From: Laura Gibbons <Laura.Gibbons@arun.gov.uk>
Sent: 01 July 2021 13:35
To: Amy Myer <Amy.Myer@arun.gov.uk>
Subject: RE: Y/80/21/DOC - REVISED ENGINEER COMMENTS

I therefore recommend discharge of condition 7. The following should be referenced in any approval:

- 424927/201P4 Surface Water drainage layout 1 of 3.
- 424927/202P4 Surface Water drainage layout 2 of 3
- 424927/203P4 Surface Water drainage details 3 of 3

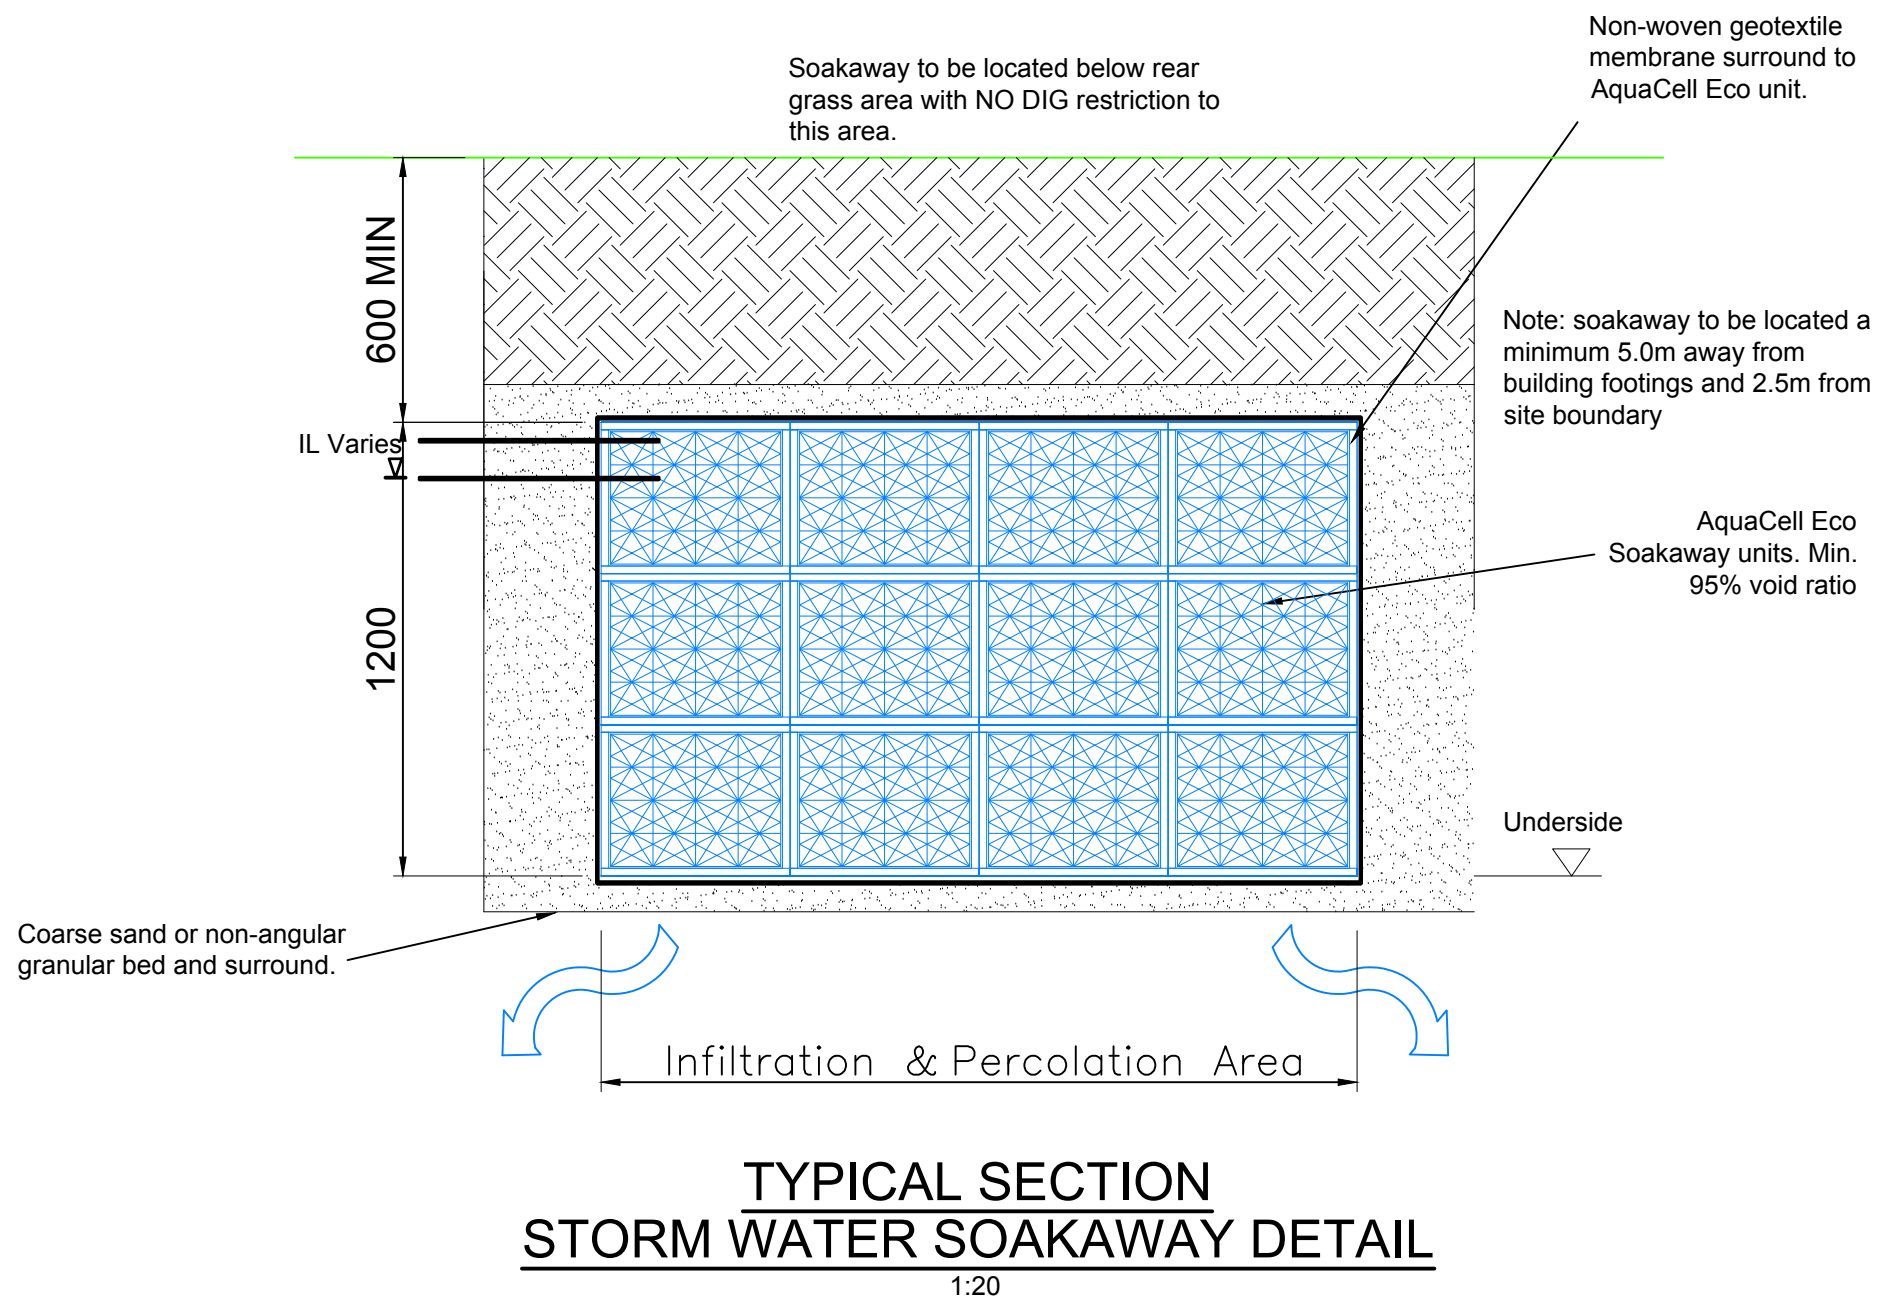
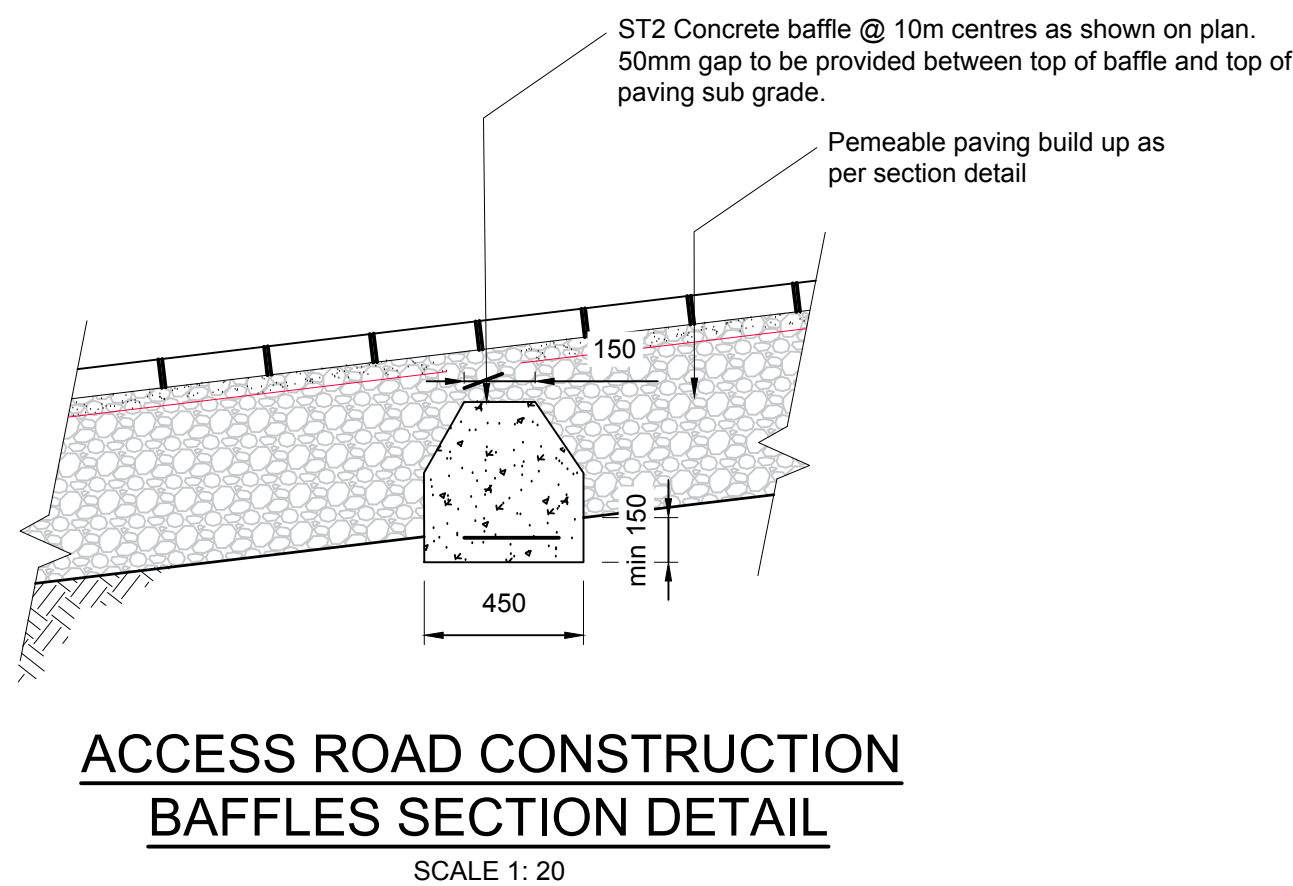
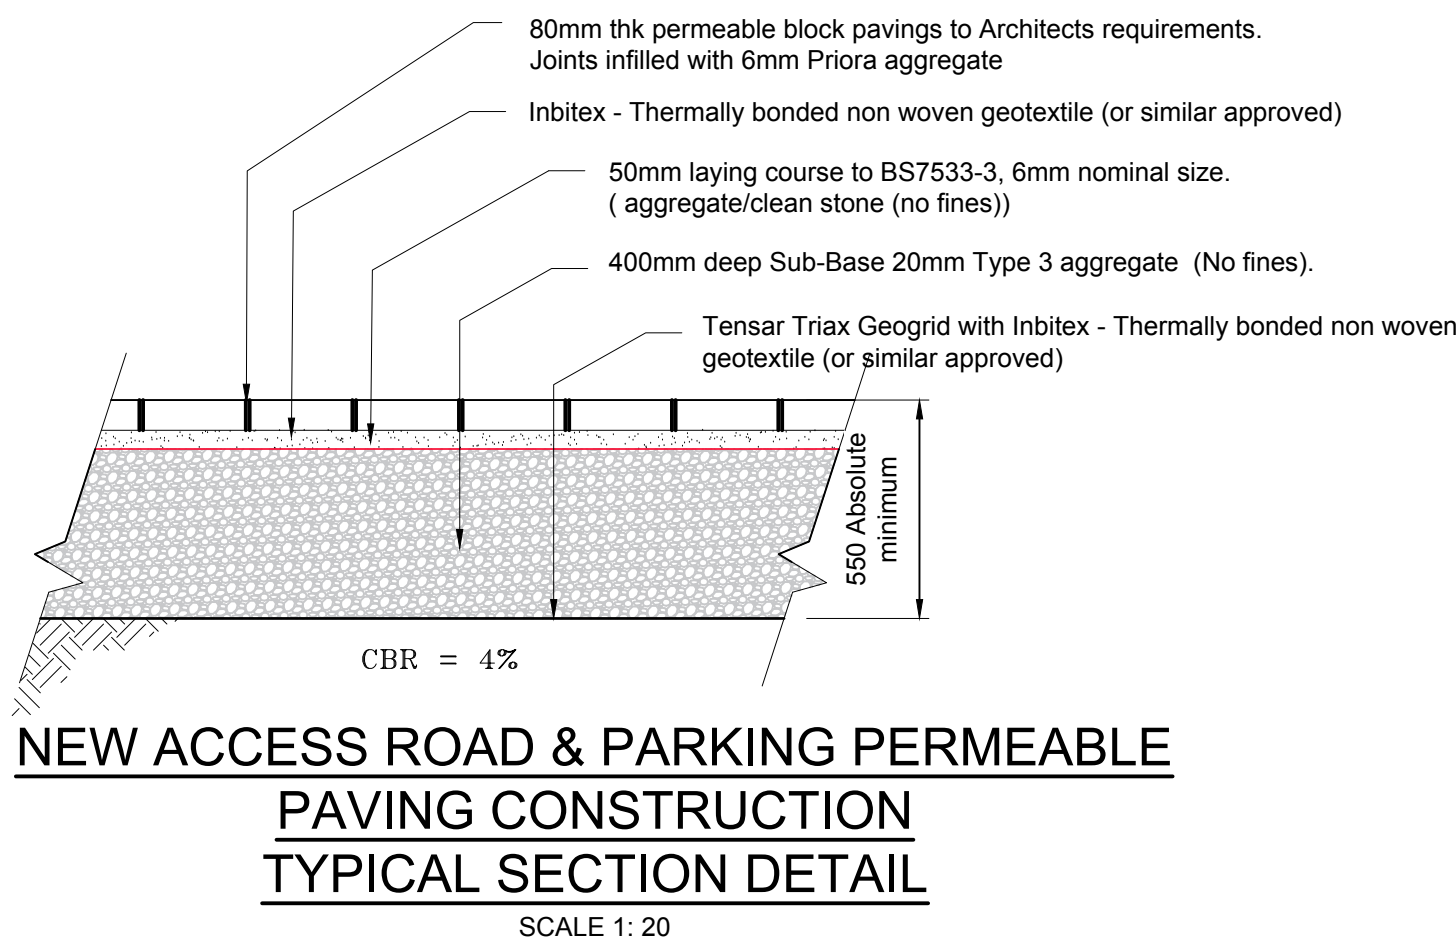
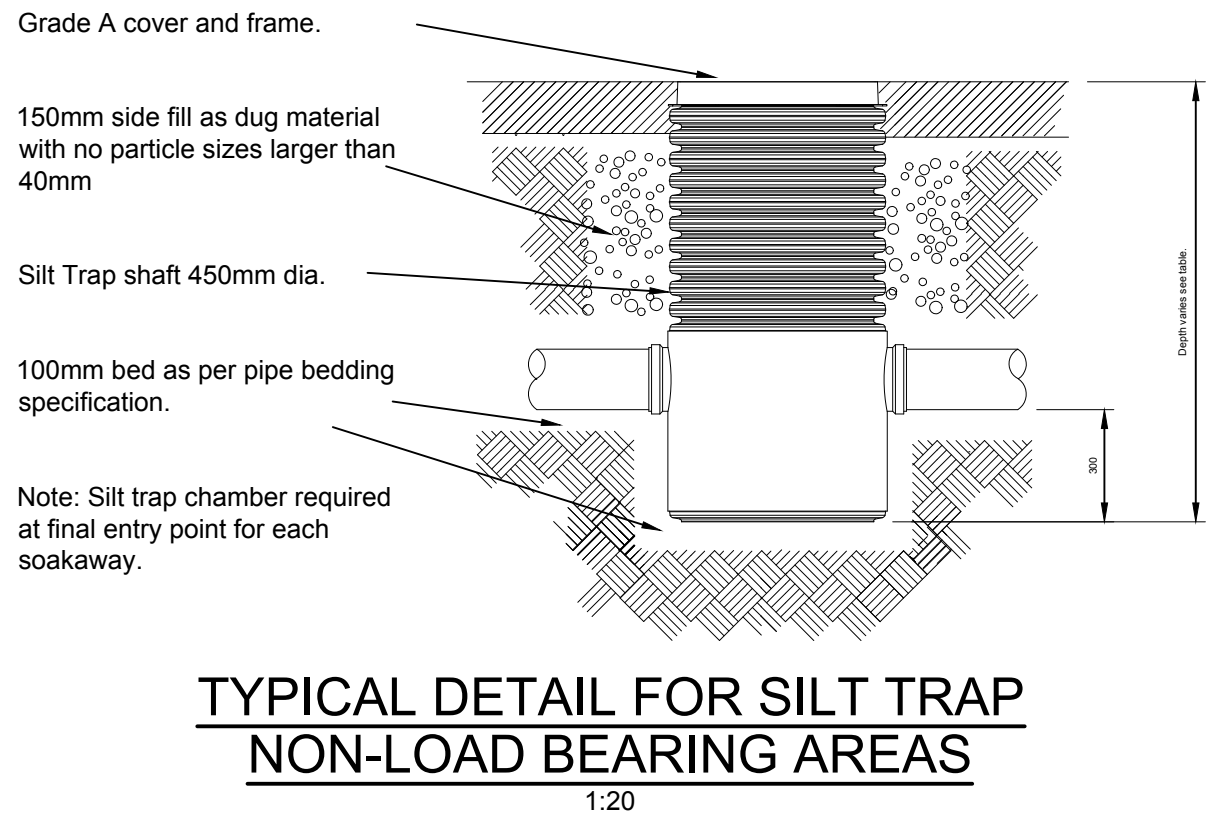
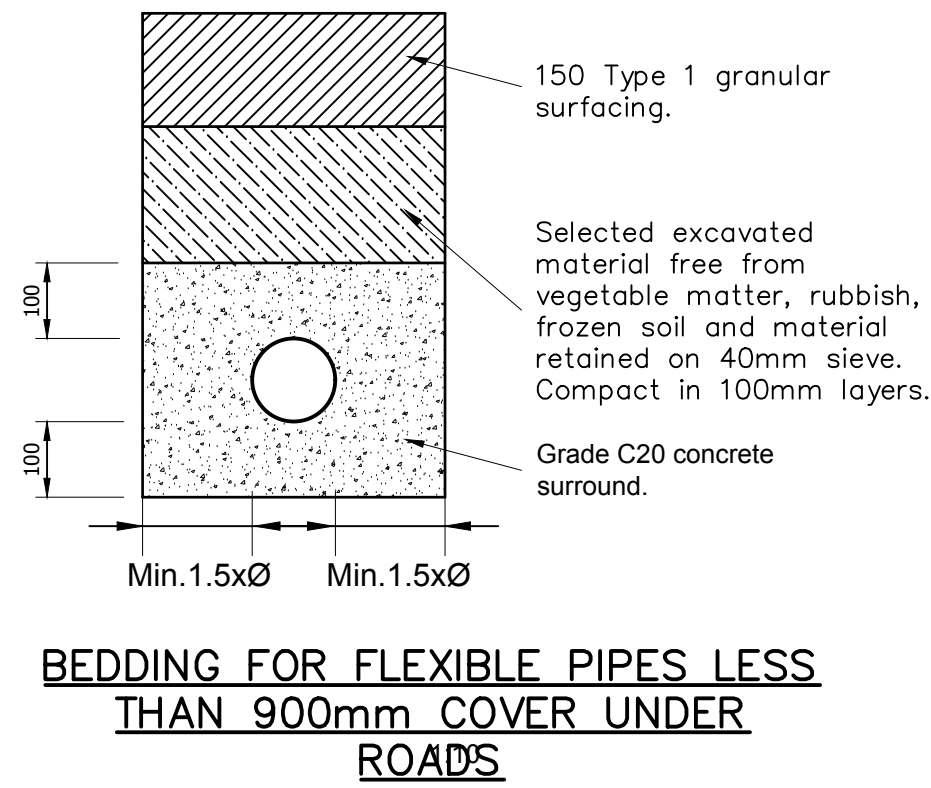
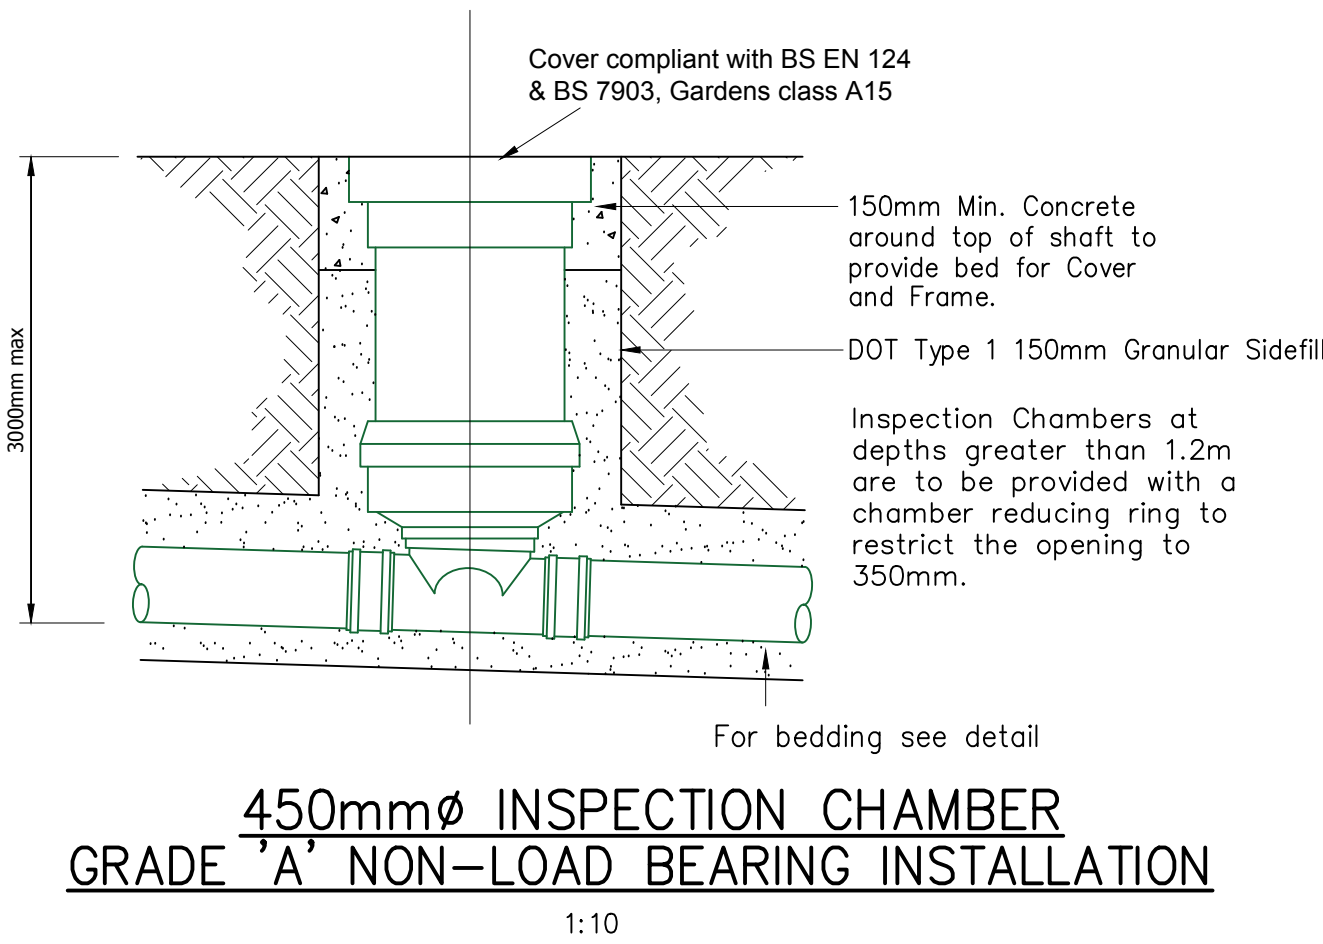
1. I have noted infiltration testing date / locations on the plan and attached to the calculations.
2. I have applied the shallower depth infiltration testing results to the permeable paving design and updated the calculations / drawings. Sub base depth increased to 400mm.
3. Drawings updated (and attached) with permeable paving finish and formation levels.
